Application no: **3/2021/1040**

Address: **Beacon Holme Whalley Road Simonstone BB12 7HT**

Proposal: **Variation of S106 agreement attached to planning permission 3/1993/0056 in order to allow the annexe known as Littleholme to be sold or let as a separate dwelling.**

The Local Highway Authority have viewed the plans and highway related documents and have the following comments to make:

proposed additional accommodation

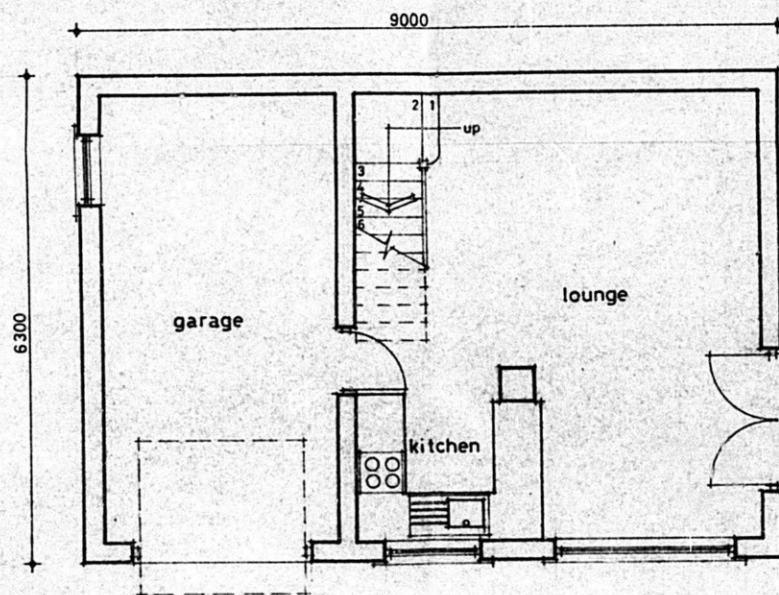
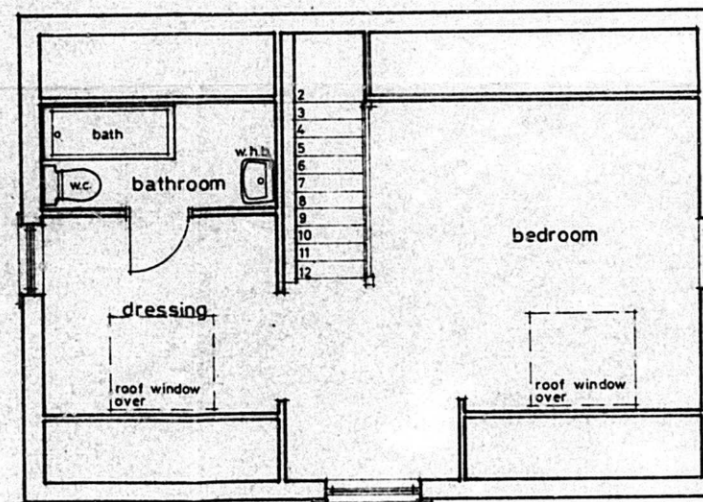
The LHA have reviewed the approved plan under application reference 3/1993/0056 titled "Proposed Additional Accommodation" and understands that the annexe is one-bed and has access to an attached single garage. The parking arrangements as a result comply with the Joint Lancashire Structure Plan, with the parking for the proposed dwelling being provided in the attached garage. Therefore, the LHA have no further comments to make.

1. The existing garage shall be kept available for the parking of vehicles and shall not be used for any use that would preclude the ability of their use for the parking of private motor vehicles, whether or not permitted by the provisions of the Town and Country Planning (General Permitted Development) Order 2015 or any order amending or revoking and re-enacting that order.
